The Lake Lothing (Lowestoft) Third Crossing Order 201[*]

Comments on responses to the ExA's Second Written Questions and to Interested Parties' Representations Submitted at Deadline 8

Author: Suffolk County Council

Date: 26 April 2019

DRAWING TITLE
 NON MATERIAL CHANGES
 OVERVIEW PLAN
 SHEET 2 OF 2

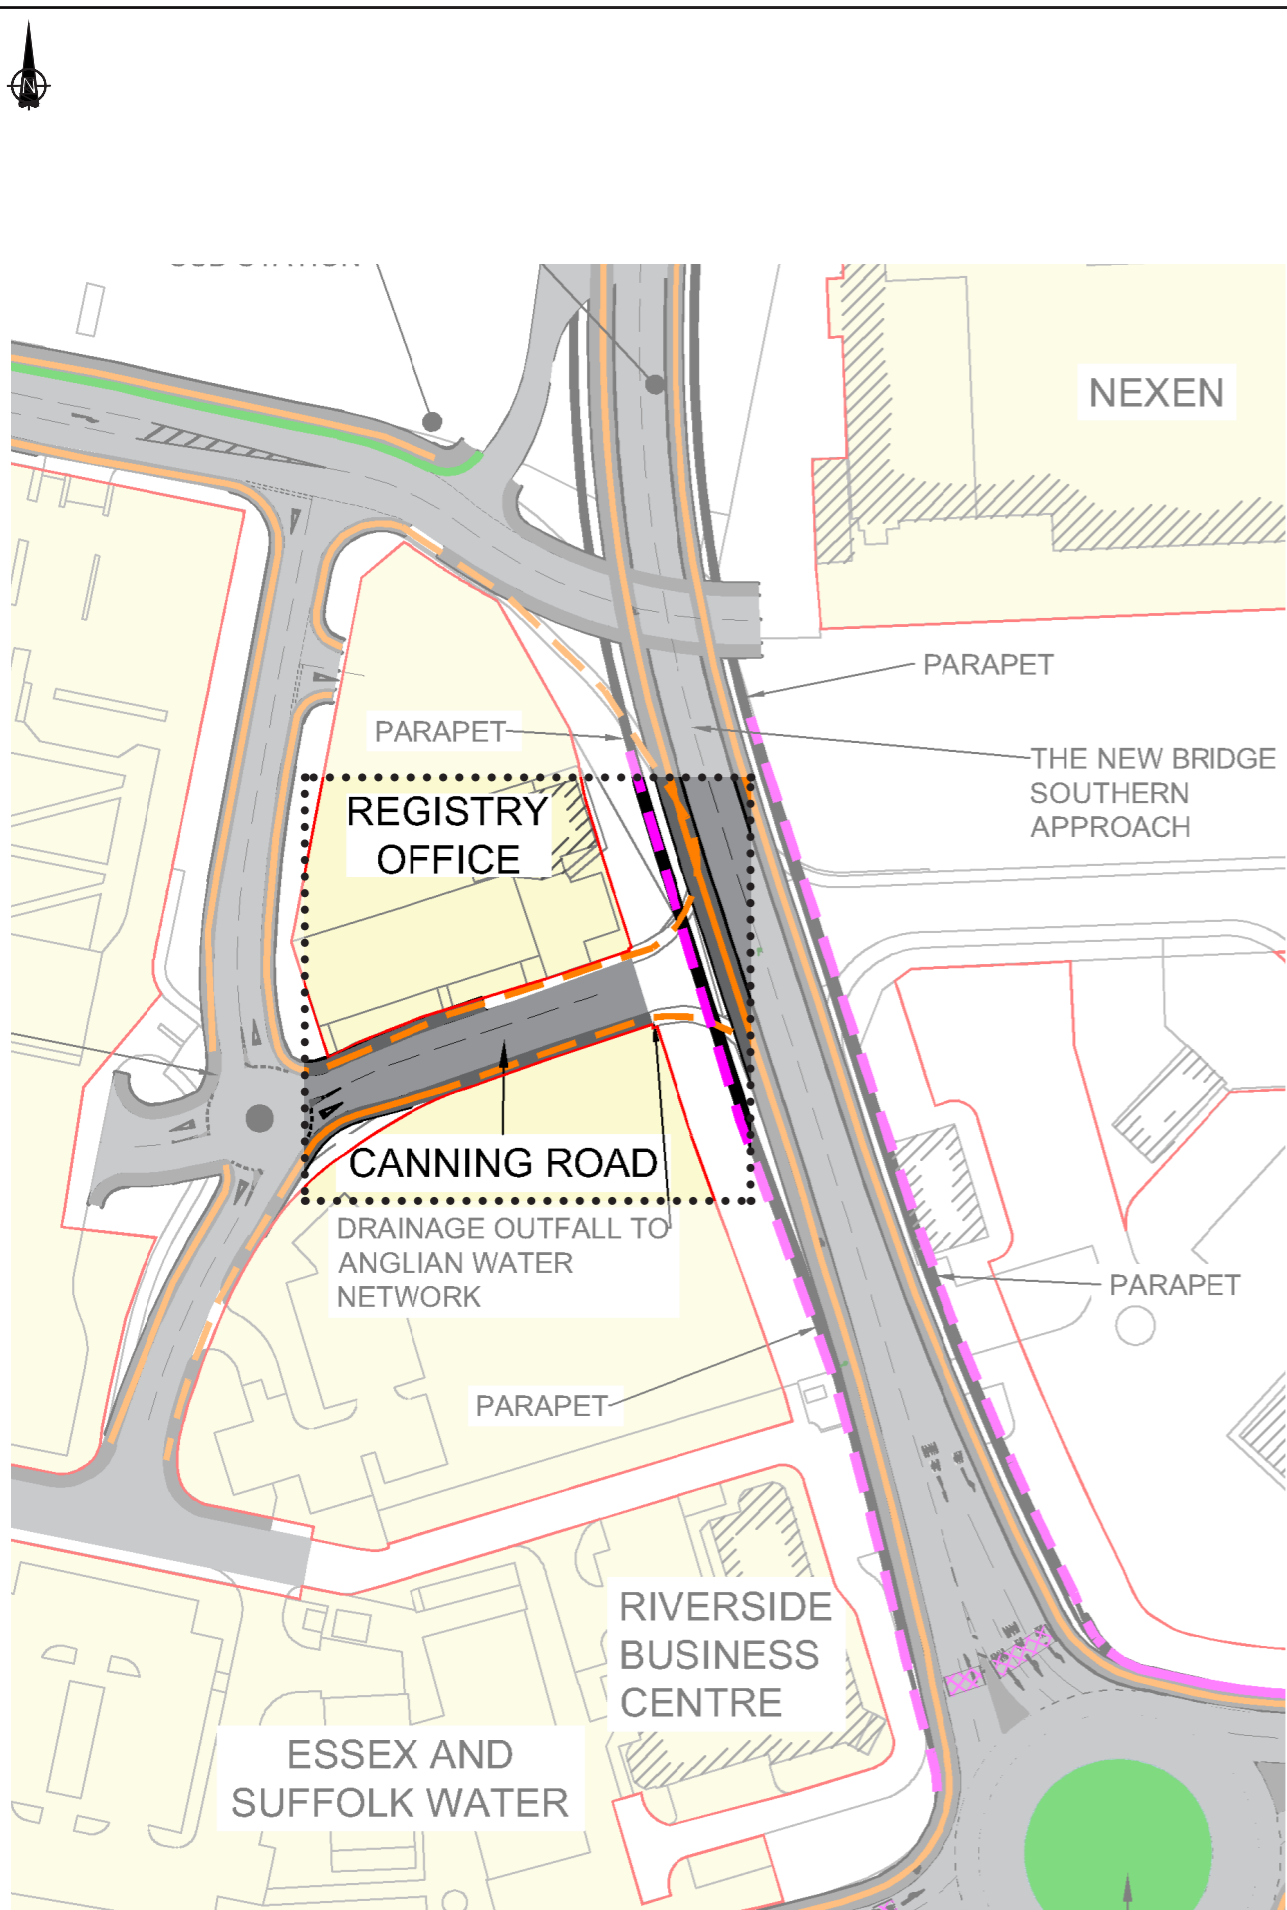
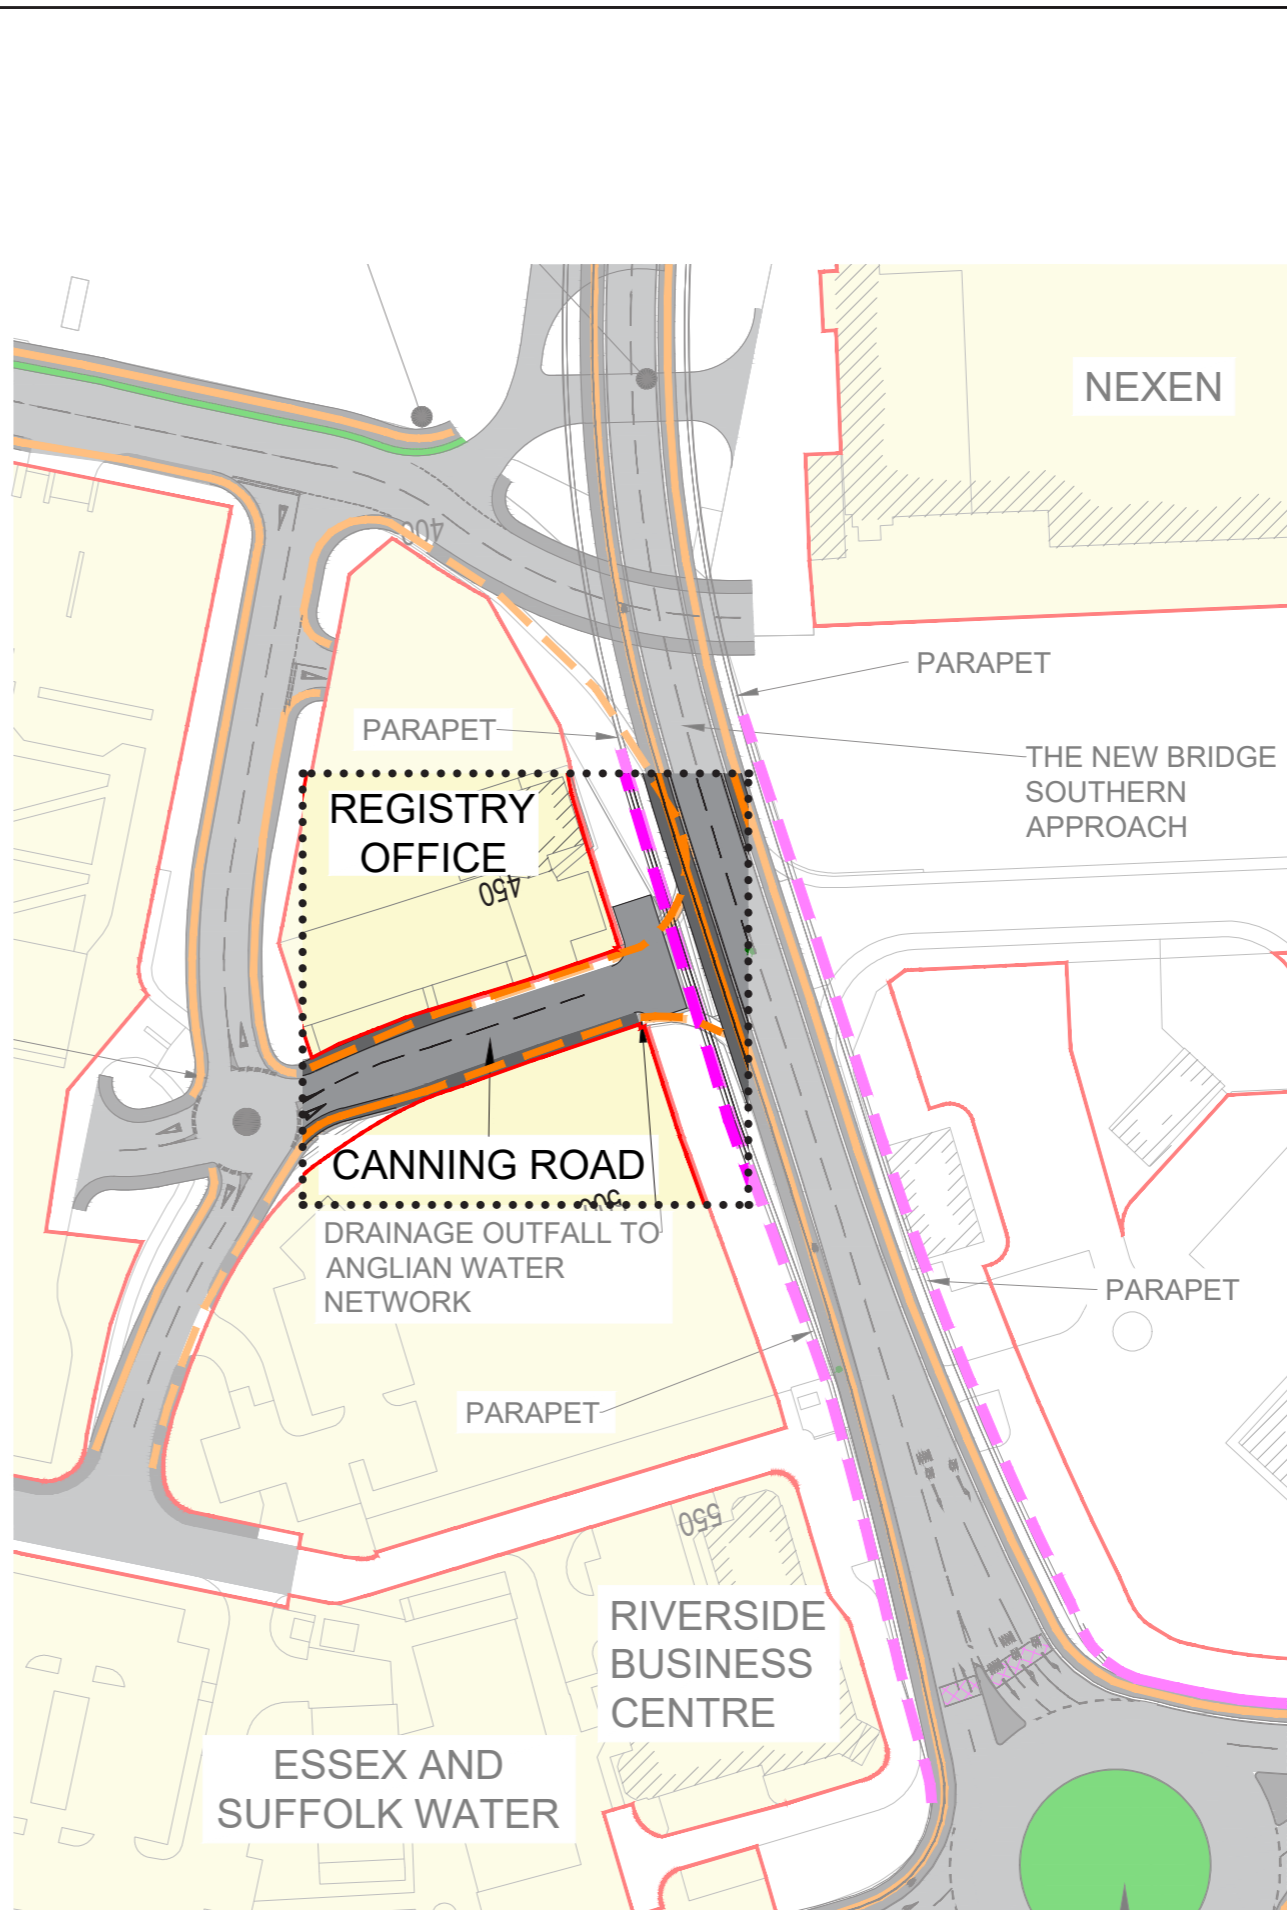
Question number	Question	IP's response	Applicant's response
1.15	In the response to the Applicant's NMC6 proposed change to the scheme [REP7-003, Appendix I], the Nexen Group suggest that a low-loader would have to "pass in very close proximity to [...] any vehicle parked up and waiting at" the factory doors. Currently, how would a low-loader be able to pass a vehicle so parked at the doors?	<p>In responding to this question, I would first point out that it is not only the low-loader manoeuvre that provides a cause for concern. It is in fact a situation that arises for all hgv manoeuvres. The low-loader is simply an example situation and has been described previously because this is the only vehicle for which swept path analysis has been undertaken and provided by the Applicant.</p> <p>I provide a number of new vehicle swept path drawings to illustrate i) the existing situation and ii) the worsened situation that would be created by the Applicants access proposals for the Nexen site.</p> <p>It is apparent from NEXEN.2/01 and NEXEN.2/02 that the existing access layout allows for a large articulated lorry or a low-loader to enter the site and to drive past a vehicle parked at the factory 'goods-in' door.</p> <p>It is apparent from NEXEN.2/05 and NEXEN.2/06 that the Applicant's proposed access does not provide sufficient space for a large articulated lorry or a low-loader to pass a</p>	<p>A low loader has been used to date track vehicular movements at the request of Nexen as it was identified as the most onerous of vehicles to manoeuvre in and out of the site. Nexen previously indicated that the Applicant's analysis was flawed in that it had not tracked a low-loader without trailer steering (see paragraph 13.8.5.1 of its Written Representation), hence this was provided for in subsequent tracking.</p> <p>The Applicant has reviewed the tracking exercises undertaken by Mayer Brown on behalf of Nexen and while it does not consider it would assist the Examining Authority to repeat those manoeuvres or undertake additional ones of which the permutations are numerous, makes the following observations:</p> <p>NEXEN.2/01 shows FTA articulated vehicle (16.5m) tracking into site from Riverside Road. In order to make the left turn on entry to the site, the vehicle uses the full width of the entrance into the site, at risk of encountering oncoming traffic exiting the site.</p> <p>NEXEN.2/02 FTA articulated vehicle (16.5m) tracking into site from proposed access. In this instance the vehicle avoids using the full width of the entrance in</p>

Question number	Question	IP's response	Applicant's response
		<p>vehicle parked at the factory 'goods-in' door. The existing access arrangement allows the entering vehicle to pass the parked up delivery vehicle in a straight line of travel and with good visibility of operatives on the ground attending the delivery vehicle.</p> <p>The position of the Applicant's proposed access, in close proximity to the Nexen goods-in door, presents an increased safety concern for operatives attending a parked delivery vehicle. The attention of the driver, being drawn to making a turn to enter the site and seeking to avoid the parked delivery vehicle, increases the chance of him not seeing an operative standing on the ground with the potential for the operative to be struck.</p> <p>The north access proposal of Nexen (as described in greater detail below in the response to Question 1.16) would remove any risk from the entering vehicle having to pass a parked up delivery vehicle.</p>	<p>accessing the site, causing that vehicle to require space currently occupied by the FTA rigid delivery vehicle (10m) parked at goods in door. It is unclear why a different approach to vehicular tracking is taken to the proposed access to the existing access (for the assistance of the ExA, swept path analysis is simply undertaken by an operator 'driving' a virtual vehicle of their choice on a route of their choice).</p> <p>If a similar principle is applied to the proposed access as applies to the existing, i.e. that the full width of the entrance may be used then the Applicant considers the vehicle would avoid the stationary vehicle when accessing the site.</p>

1.1.6	In the response to the Applicant's NMC6 proposed change to the scheme [REP7-003, Appendix I], the Nexen Group suggest that "an	In responding to this question, I would first point out that the manoeuvre to park a low-loader at the factory doors is not a common occurrence. Rather, the vehicles that park at the factory doors are more usually large articulated or large rigid delivery vehicles. The low-loader is simply an example situation and has been described previously because this is	<p>NEXEN.2/05 illustrates a low loader tracking past a stationary FTA rigid delivery vehicle (10m) parked at the goods in door in the current situation and NEXEN.2/06 shows the same through the proposed access.</p> <p>A similar point to that above arises, where the movement of the low loader is more constrained by</p>

Question number	Question	IP's response	Applicant's response
	alternative access route further to the north should be considered". How would a low-loader then service the existing factory doors on the western façade of the building?	<p>the only vehicle for which swept path analysis has been undertaken and provided by the Applicant.</p> <p>I provide drawings to illustrate an alternative access route further to the north being used by large vehicles to enter the Nexen site.</p> <p>It is apparent from NEXEN.2/03, NEXEN.2/04 and NEXEN.2/07 that the alternative access route located further to the north can accommodate, without conflict, all the turning manoeuvres of all large vehicles that use the Nexen factory site.</p> <p>The north access would also provide greater assurance to Nexen that unhindered access to the factory site can be provided at all times, including during the LLTC construction phase. The separation of this access from the existing Nexen access would mean that construction works can be undertaken to a staged programme that requires work in the vicinity of only one access location at a time.</p> <p>5. The alternative north access is also part of a three access strategy (the third access being the access road on the east side of the adjacent Lings property) that Nexen seek to ensure access/egress at all times, particularly during periods of construction and</p>	<p>the operator in tracking through the proposed access compared with the current access. In this case the entering vehicle uses the entire width of the current entrance way (i.e. both sides of the carriageway) and additionally tracks noticeably closer to the western boundary of the site than it does through the proposed access. Consequently, a conflict is created, which again with comparable operator decisions in the no-Scheme and Scheme world may be avoided.</p> <p>With regard to the northern access proposed by Mayer Brown, the Applicant notes that in its representation on Non-Material Change 6 (i.e. the proposed Nexen second access), the Mayer Brown Report 3 stated at paragraphs 4.6 to 4.10 <i>"the proposed site access of NMC #6 will add a reversing manoeuvre into the vehicle approach to the factory doors, with associated safety implications"</i> and further... <i>"reversing to the factory doors will increase the risk of a collision with another vehicle or with a worker in the vicinity"</i> and that this situation would be <i>"overcome ...[with] an alternative access route further to the north"</i>. The Applicant cannot therefore reconcile these comments with the lengthy reversing manoeuvre that would be required with the Nexen northern access proposal, shown in NEXEN.2/07.</p> <p>In summary, for reasons explained in previous representations in particular Appendix K of the Applicant's Consultation Report on the Proposed</p>
